Karen Harragon
Director, Social and Infrastructure Assessments
NSW Department of Planning, Industry and Environment

SSD-11920082 - HASTINGS PCYC - Departures and Modifications from the SDRP Assessment Report

Following approval of SSD application numbered SSD-11920082 and dated 1st December 2021 for the Hastings Secondary College in Port Macquarie, the PCYC component of the project has undertaken a detailed value engineering process in order to control costs and to ensure the success of the project. Following is a breakdown of the main design changes resulting in this application for an SSD modification.

title
General Arrangement Plans
General Arrangement Plan - PCYC Level 1
Plan

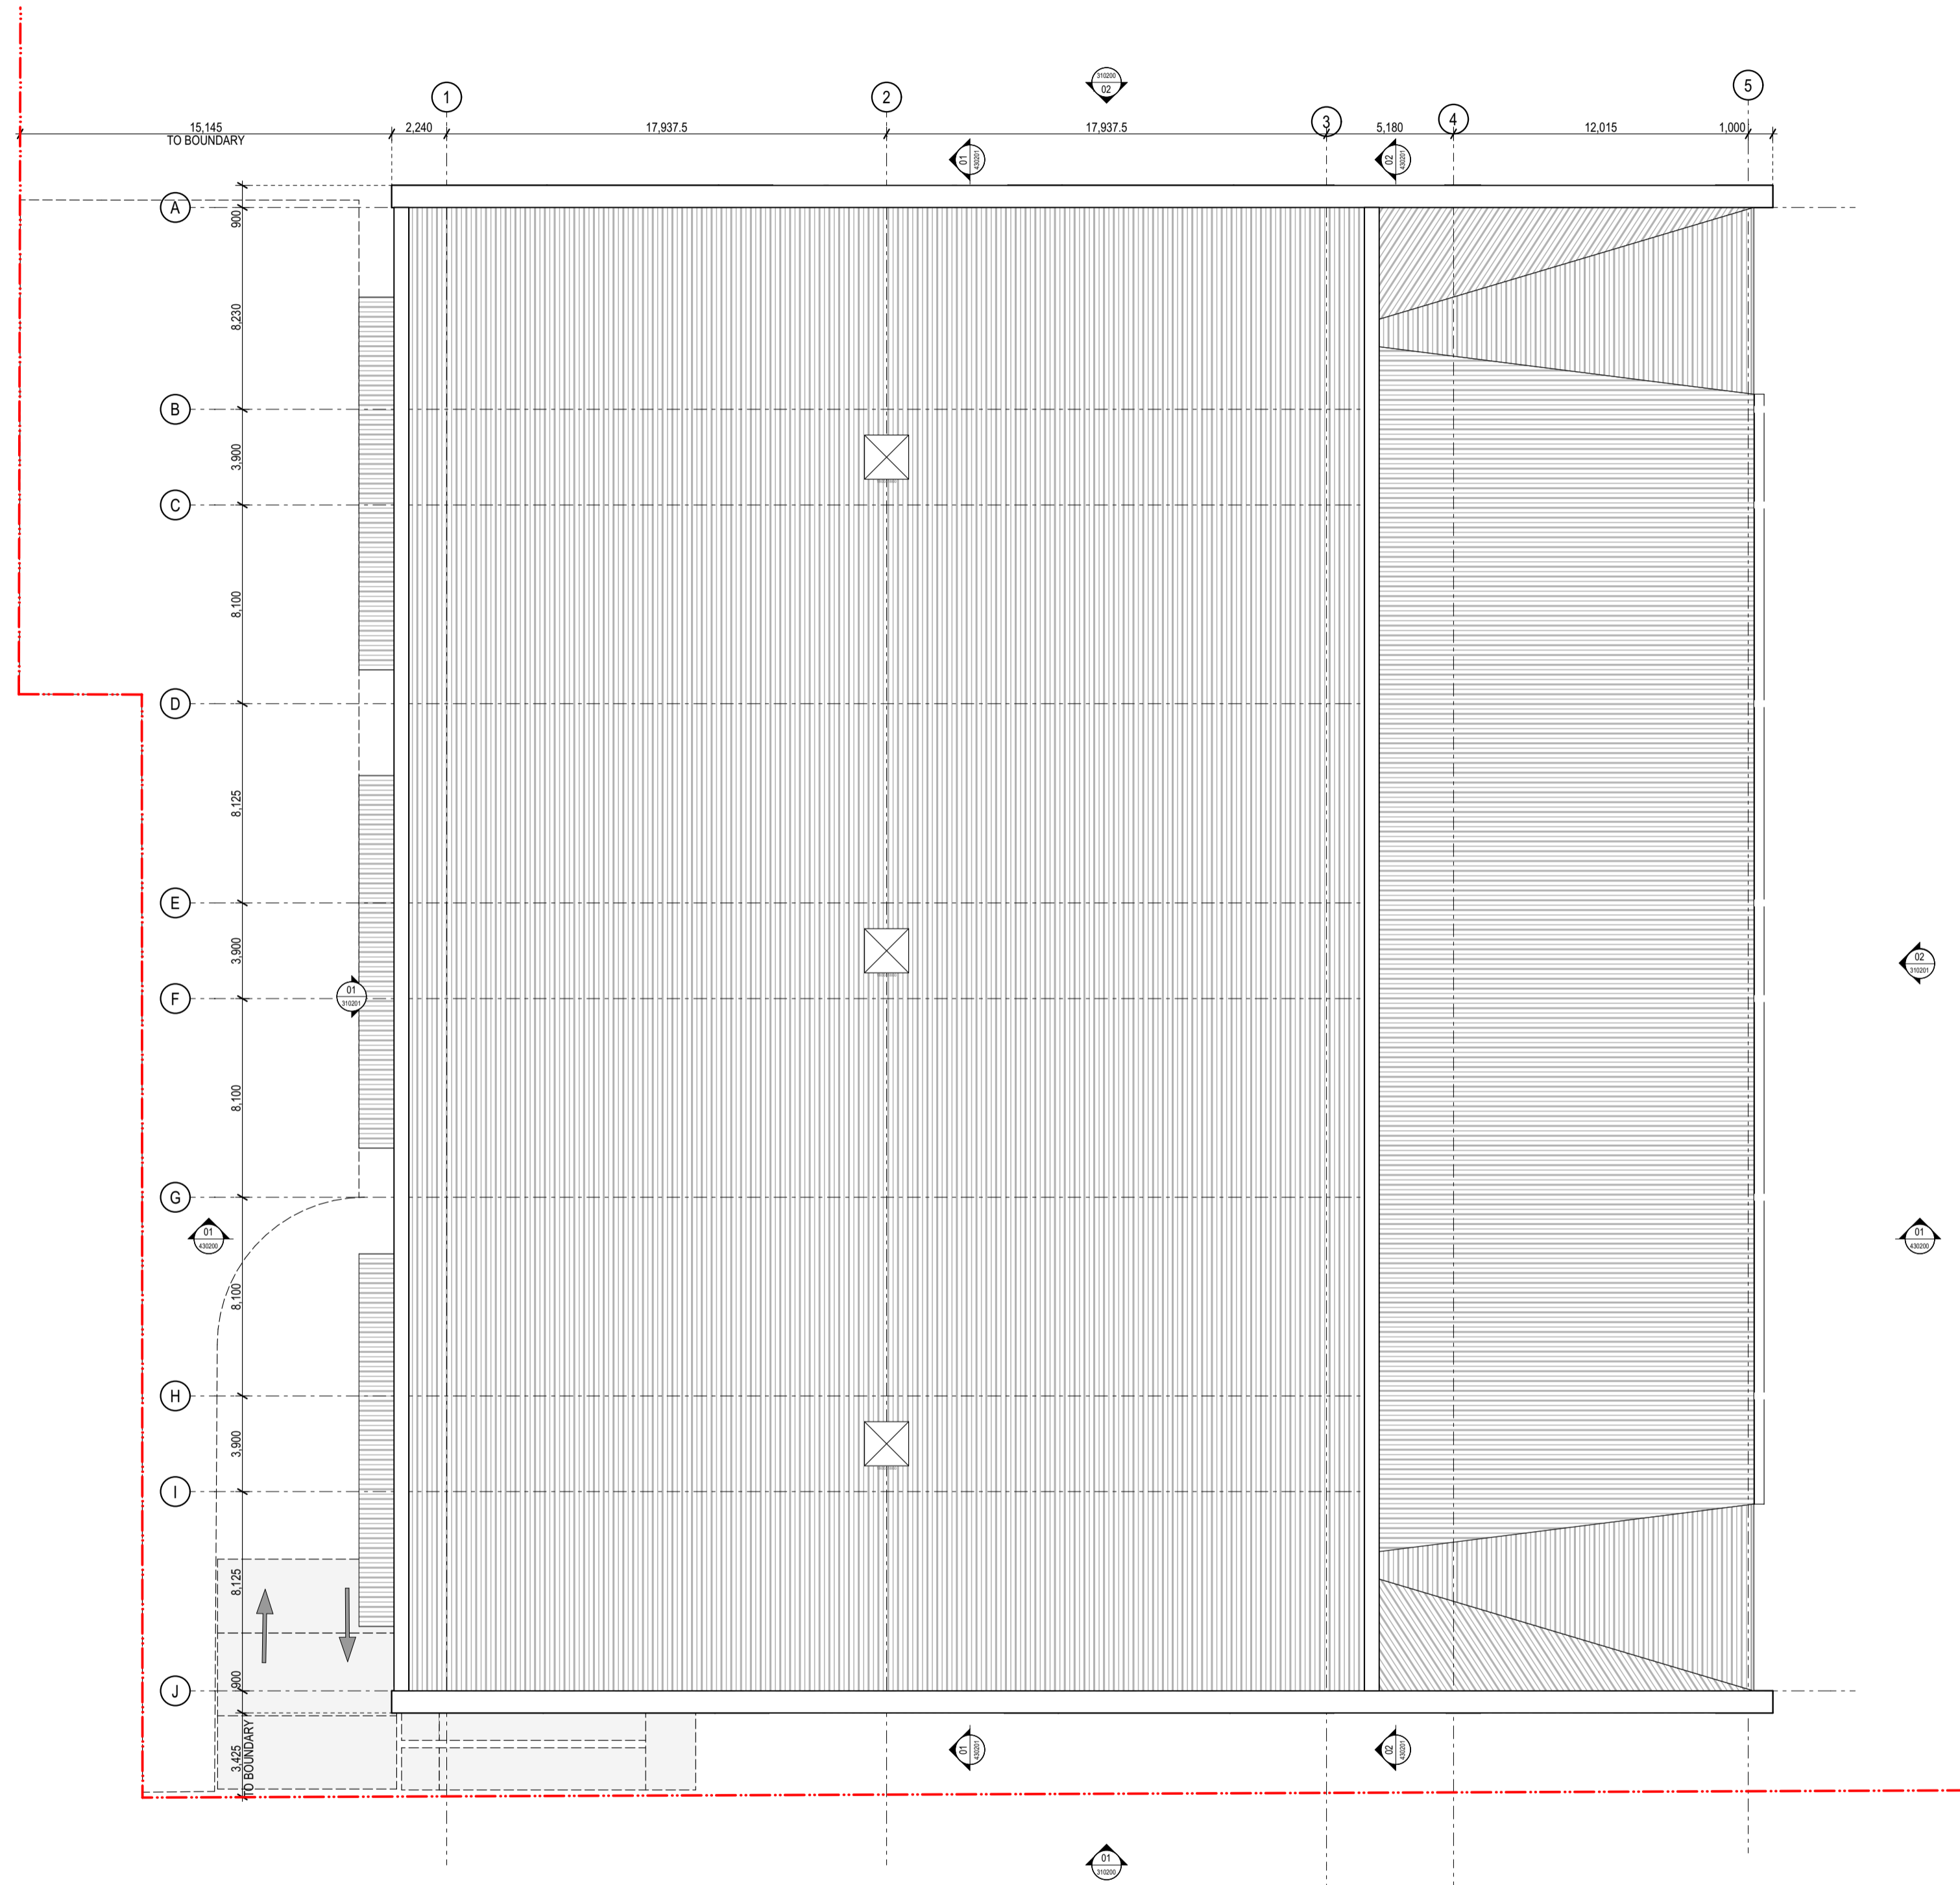
- The provision of 19 carparking spaces has been maintained, however the parking has been moved from an underground carpark to at-grade parking at the rear of the building. This on-grade solution removes the need for deep excavation and a complex stormwater drainage system. Equitable access is improved as paths are more level and don't rely on the maximum 1 in 14 rise, nor does the path of travel rely on the street pedestrian system (which in itself doesn't meet AS1428.1 travel requirements) to gain access from the accessible carpark to the building. The new carpark location provides direct, at-grade, controlled access to the building, or access to the reception via an at-grade footpath.
- The at-grade carpark reduces student play areas to the east of the building, however play space in excess of 10m² per student is maintained across the site.

- The public entry to the PCYC building has been moved from the south, between the existing MPC building and the new building, to the front of the site on Owen Street, where pedestrians would expect to enter the building. This new entry alignment has been carried through the reception area,

- The main gymnasium/court pavilion has been extended 5m to the east to support the gymnastics program being delivered. This has resulted in a need to adjust the uniform façade alignment to the east and provided an opportunity to incorporate increased articulation to the eastern and western facades. The stairs to the central circulation spine have been set back to help separate the northern court and southern entry/support pavilions. The main Owen Street entry has been brought forward (relative to the northern court pavilion) to highlight its importance as the entry to the facility, with a singular material used to contrast with the recessed surround and to highlight the building entry.

2 ELEVATION South Elevation 1:100

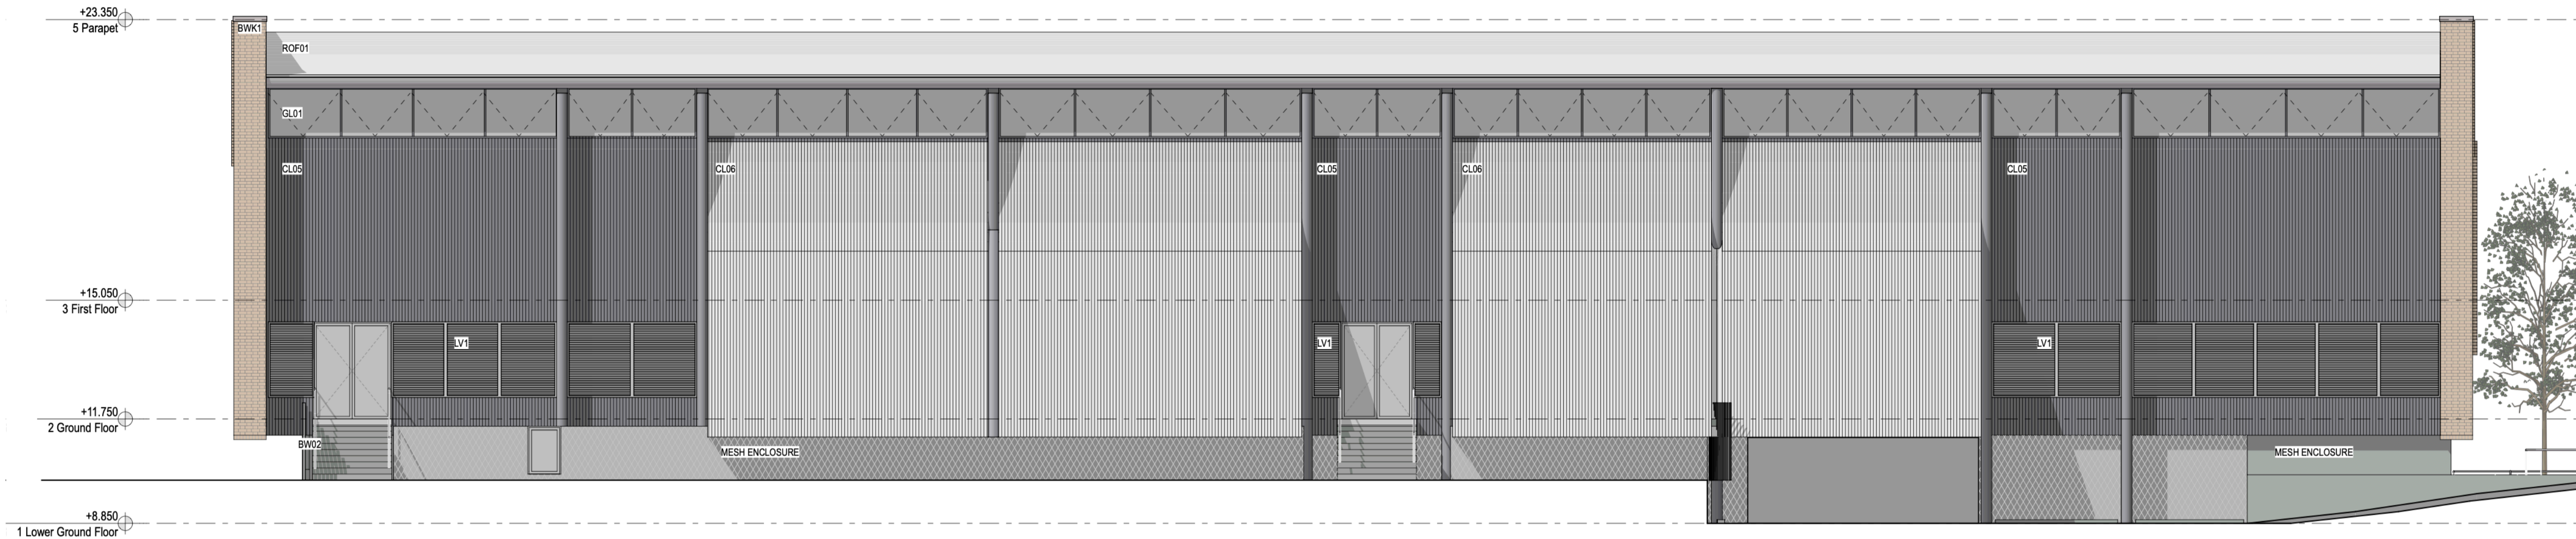
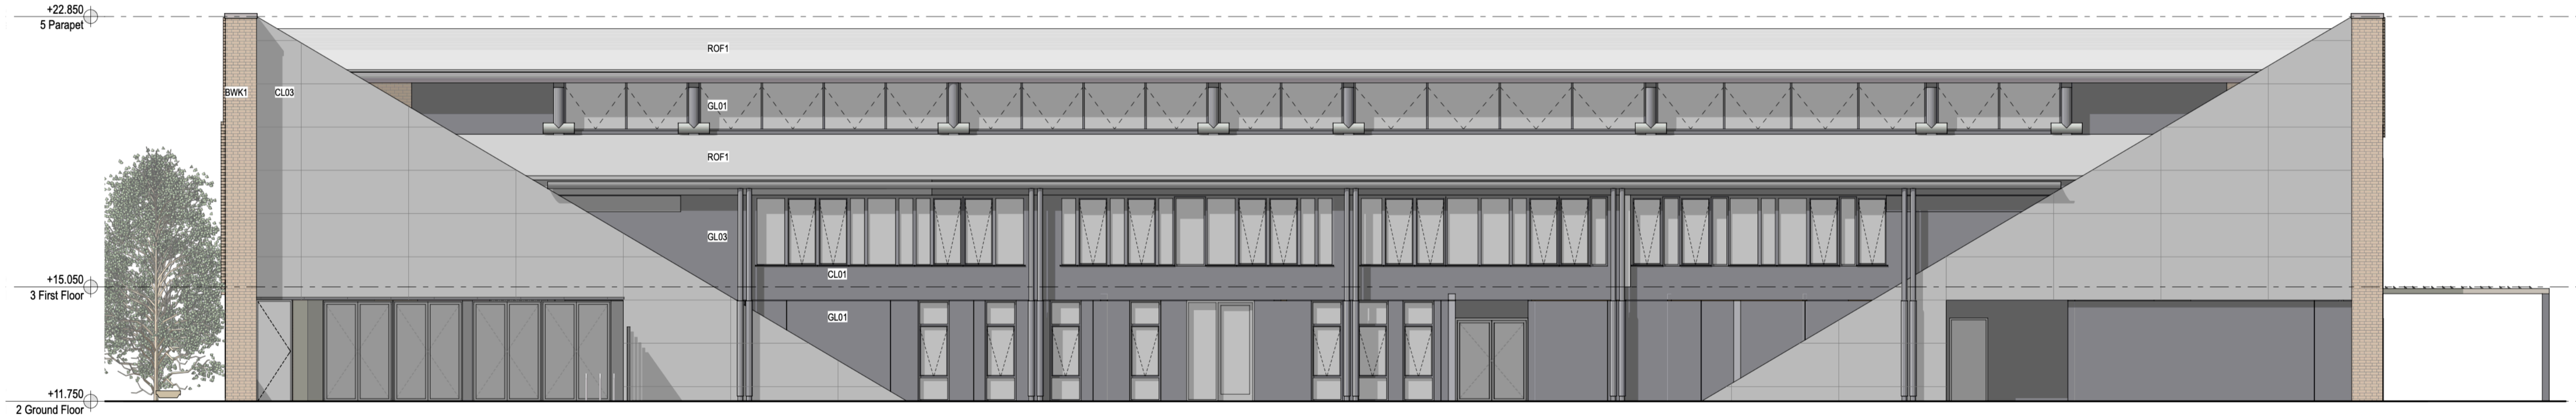
- The materiality of the eastern and western facades (Owen Street and Oxley Oval) have been changed from brickwork to pre-finished and coloured fibre cement sheeting. The complexity of the stepped, cantilevered brickwork, and resulting ongoing maintenance concerns, meant that the brickwork became cost prohibitive. The tonal contrast identified by the SDRP has been maintained with four different coloured FC panels being used to retain the undulating pattern. Each of the panels is packed out from the substrate to provide additional shadow play across the façade. Earthy tones have been retained and are similar to the previous colour scheme. The transition to light weight cladding has allowed the façade design to be adjusted slightly to reflect material properties and to emphasise the central, circular window in a more controlled manner.

- The central circular window has reduced in size from approx. 9m down to a 7.5m diameter to allow the circle to remain centred on the façade while not exposing roof and wall structure above. The roof trusses stop short of the facade, with the inclusion of traditional wall framing to allow the windows to remain as large as possible. The powder coated aluminium louvre screen is maintained, providing passive solar protection.

- The reveal to the main Entry has been changed from timber cladding to a dark, pre-finished fibre cement plank cladding. The dark cladding enhances the visual depth of the façade which further articulates the sense of arrival. The timber has been moved internally to the reception area to invite people into the heart of the building, while the retention of planks to the entry surround maintain the playfulness of mitred junctions on the different planes as pedestrians and vehicles move along Owen Street.
